PLANNING - LEVEL III REVIEW (14-526): MMC Congress Street Medical Building (285KSF) (19 procedure rooms, 64 patient rooms, licensed bed count remains 637)
 Institutional Overlay Zone

IOZ - ZONING ANALYSIS

Phase 2B  
Close sidewalk  
Remove Traffic Lights  
Extend curbing  
Update Utilities  
Install new sidewalk

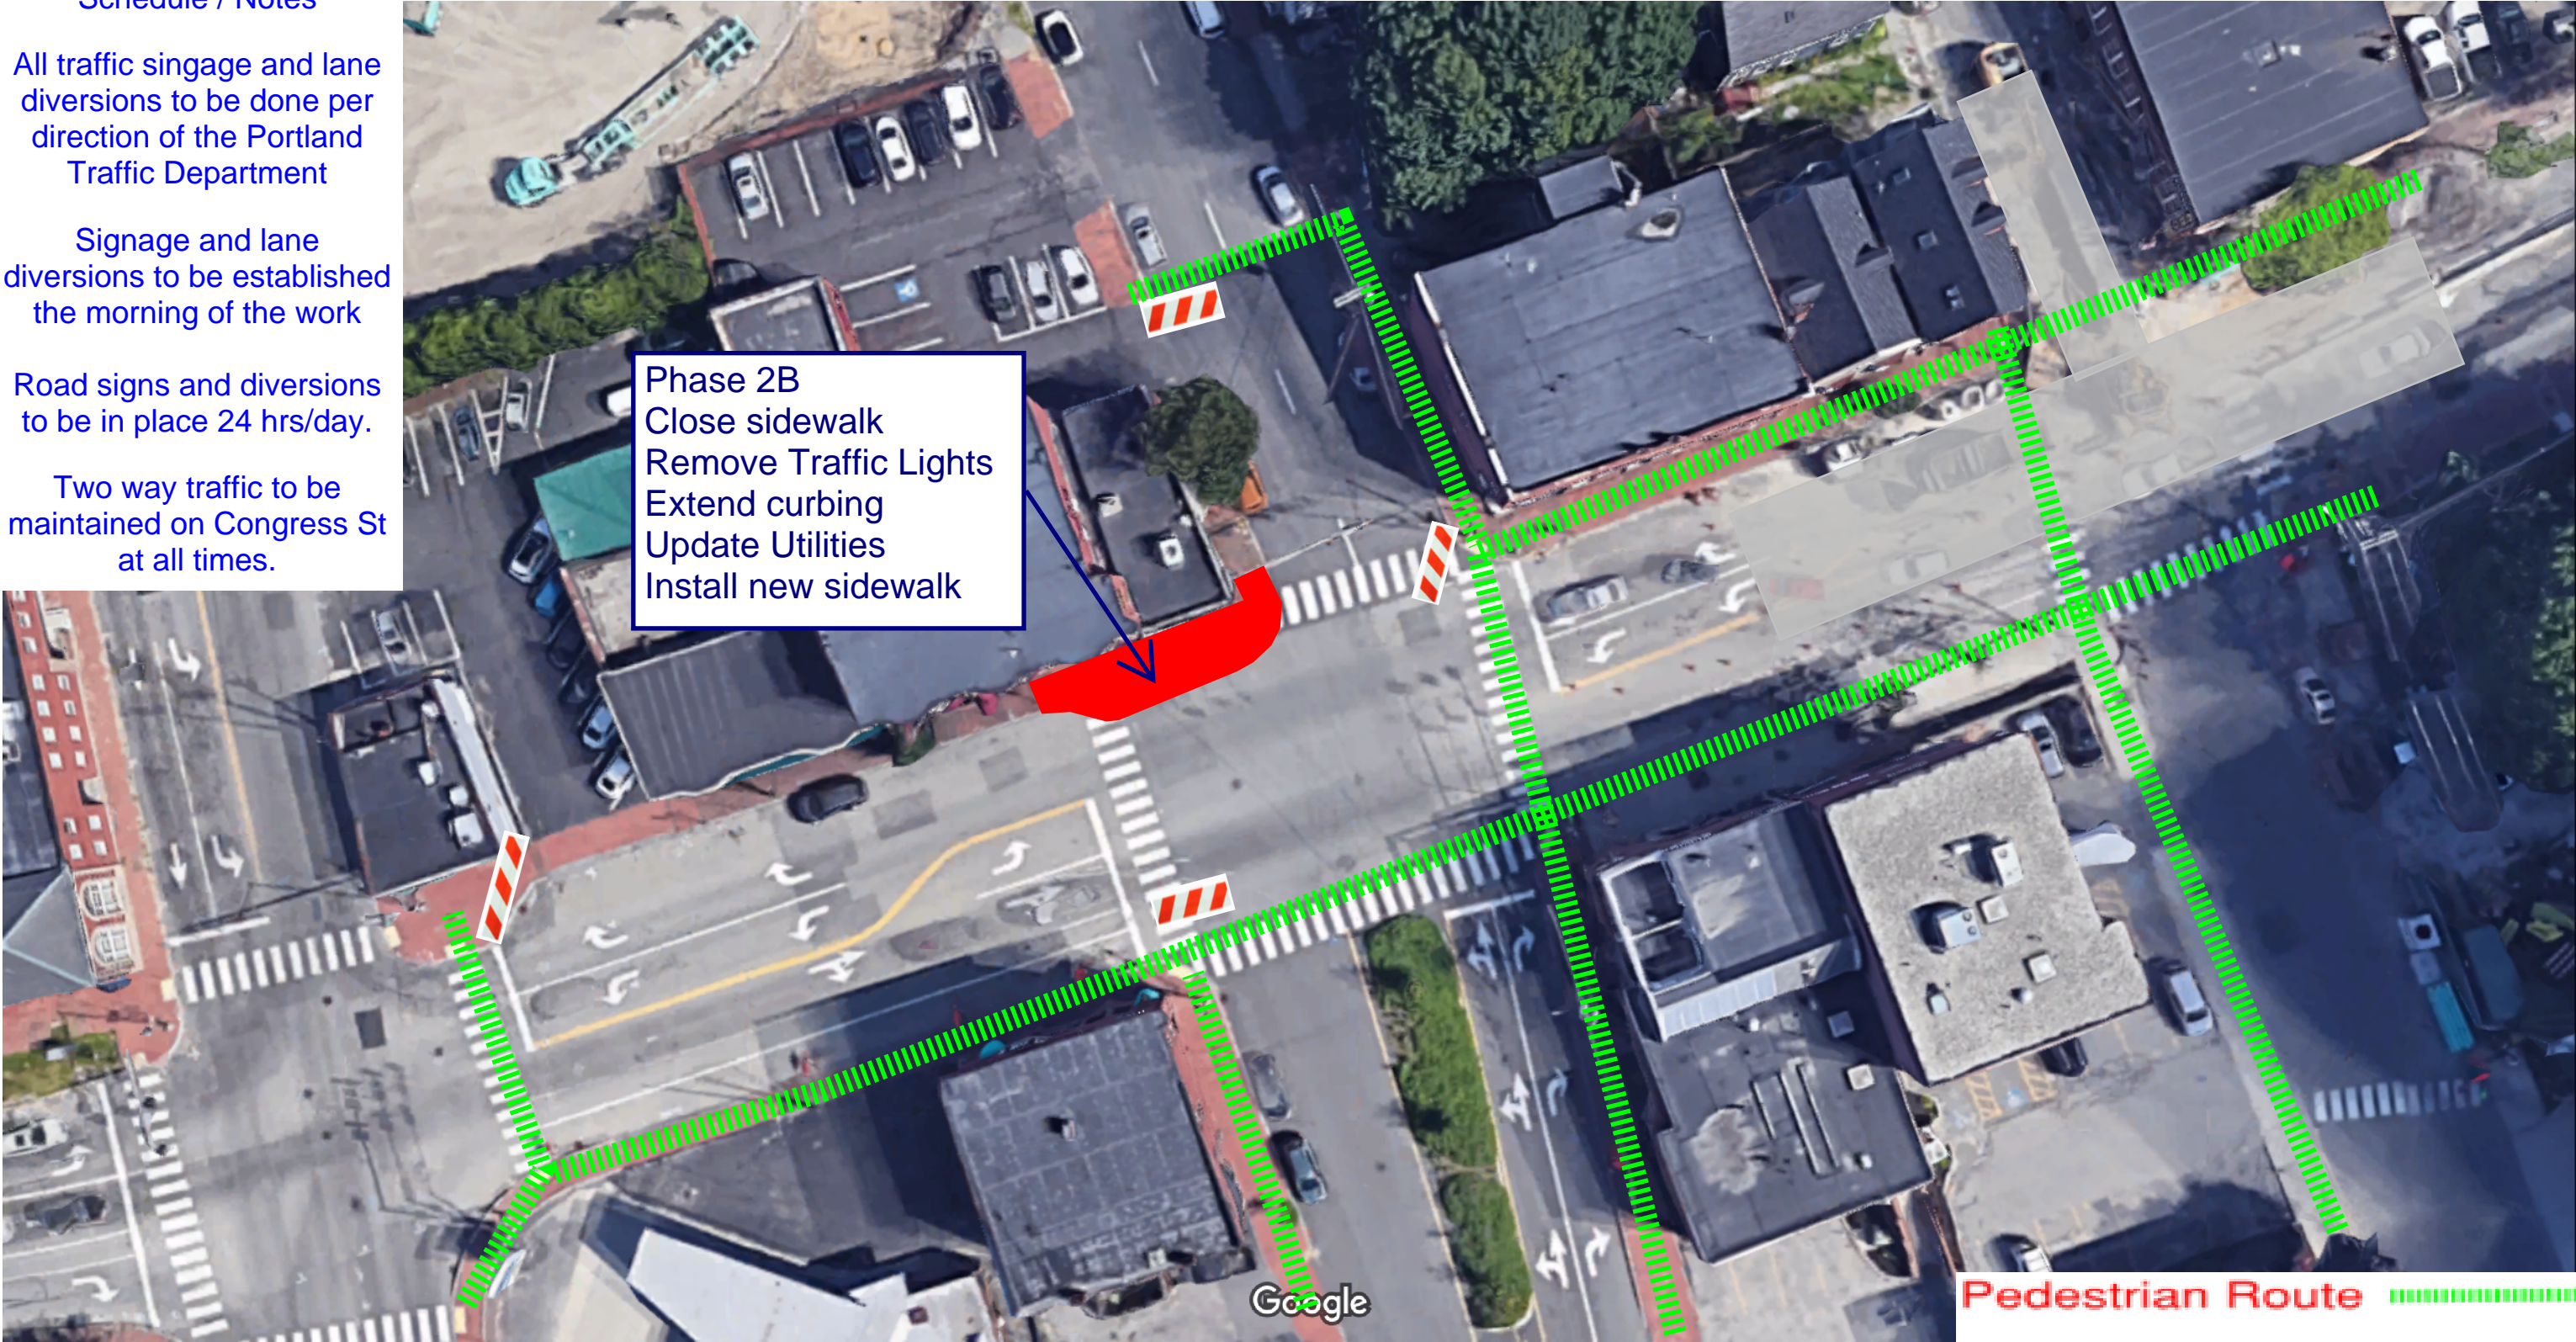
Please provide some discussion on attempts to minimize impacts to pedestrian circulation along the south side of Congress Street. Could sidewalk closure be limited to certain construction/demolition phases?

CS.2 Site Line Analysis

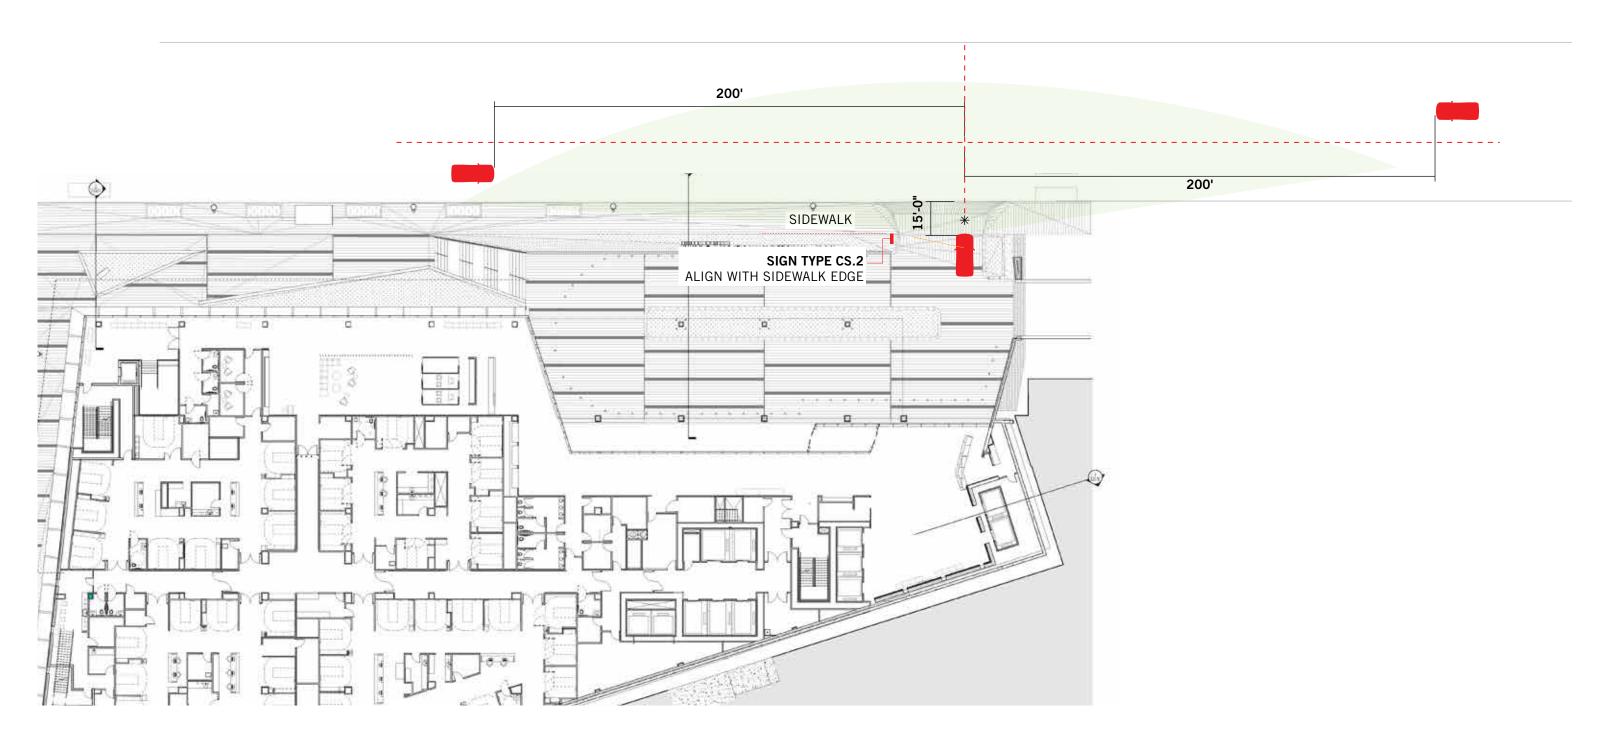
g. Noise and Vibration		
	h. Signage and Wayfinding	Revised sign plan still under review.	Please provide revised sign plan per prior comments. Provide sight line analysis
